LOCATION 488 Allen Ave (492) CBL 376 A019001

Permit Number: 091181

This is to certify that Leslie Dean/Maine Structures Co.  
has permission to Build new single family 2,040 square foot home with one car attached garage.  
AT 488 Allen Ave (492) City of Portland  
CP 376 A019001

**Ann Machado - New Single family - siteplan 2009-0076**

REAR ELEVATION  
SCALE 1/8" = 1'-0"

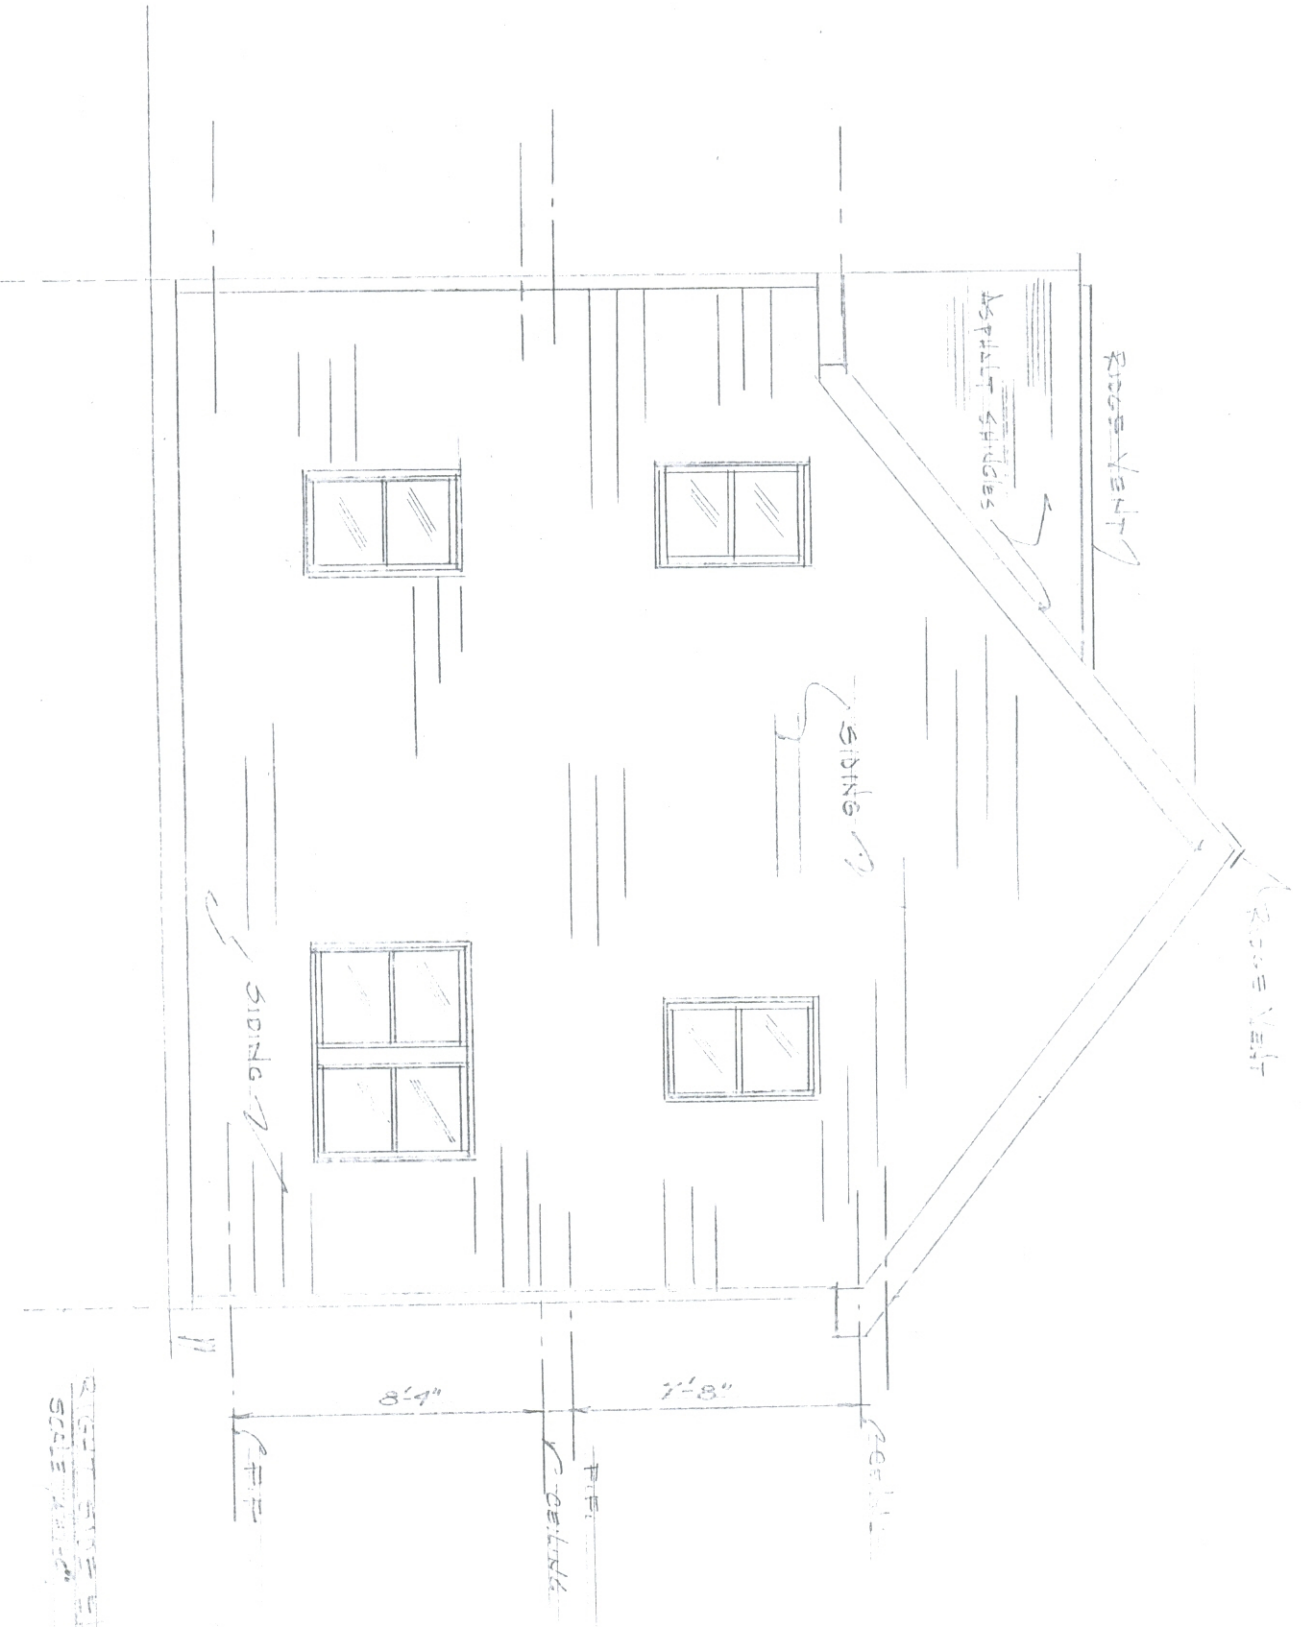
11/2/2009-amachado: Completed my review. The siteplan shows a 4' x 12' rear deck; the building plans don't. There is only one parking space beyond the 25' front setback. Emailed Phil. Waiting for him to complete his review.

I have completed my initial review. I have two issues. The siteplan shows a 4' x 12' deck on the rear but the building plans don't. There is only one parking space (the garage) beyond the 25' front setback.

488 Allen Ave  
Portland, ME

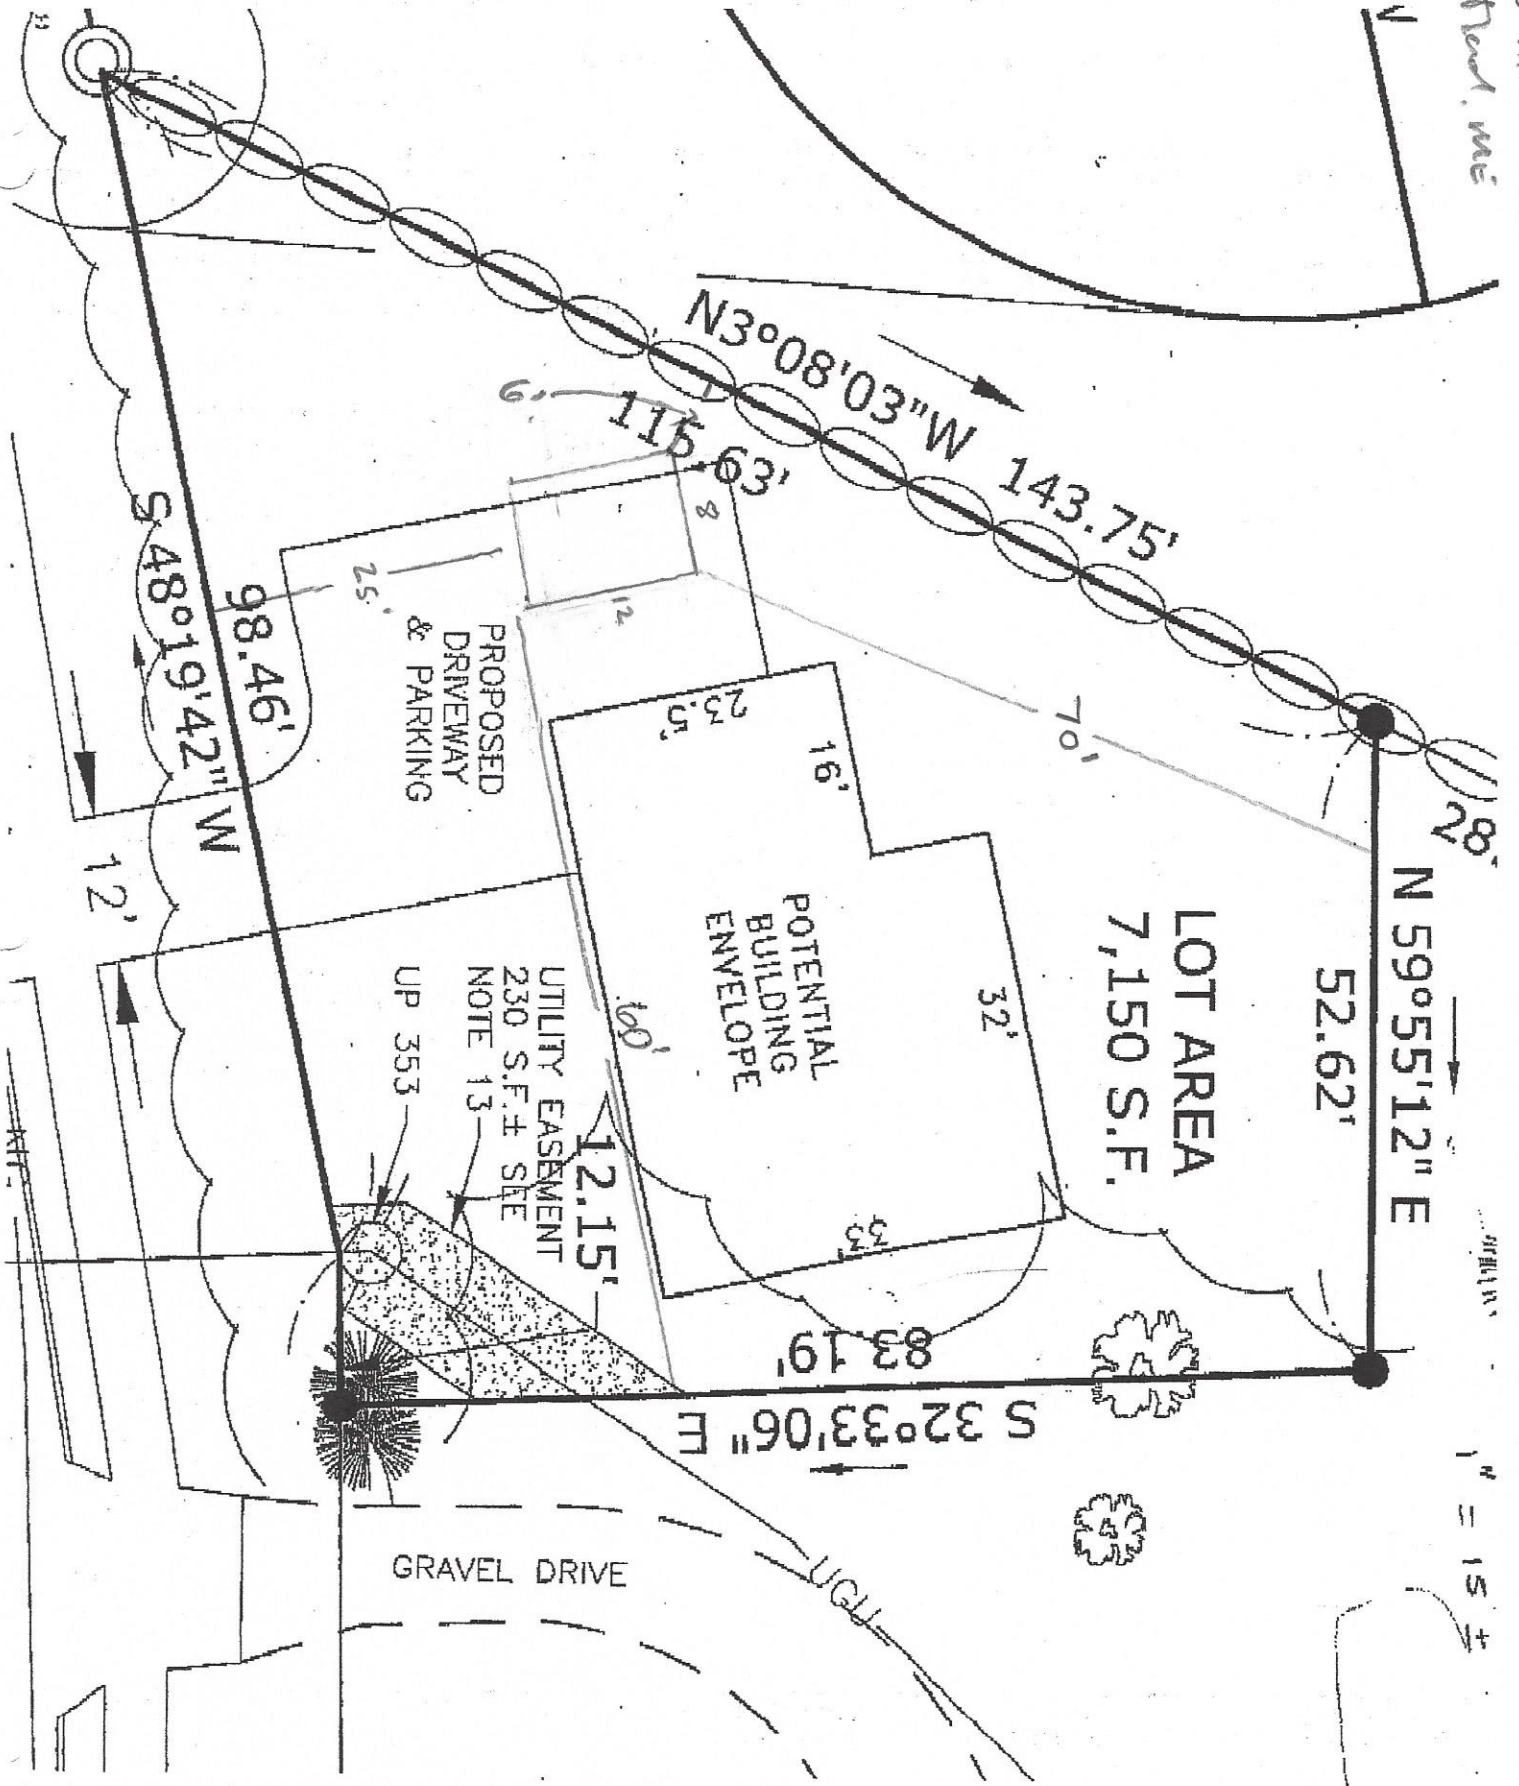
11/5/2009-amachado: Left vcm for Frank Grondidn, contractor. Site plan shows a 4' x 12' deck, building plans don't. Need a second parking space beyond the 25' front setback.

11/5/2009-amachado: Returned call to Jim Seymour at Sebago Technics. Left vcm. Explained that needed two parking spaces beyond the fornt yard setback & asked about the 4' x 12' deck.

11/6/2009-amachado: Received revised siteplan from Frank Grondidn.

\* revised site plan 11/6/09
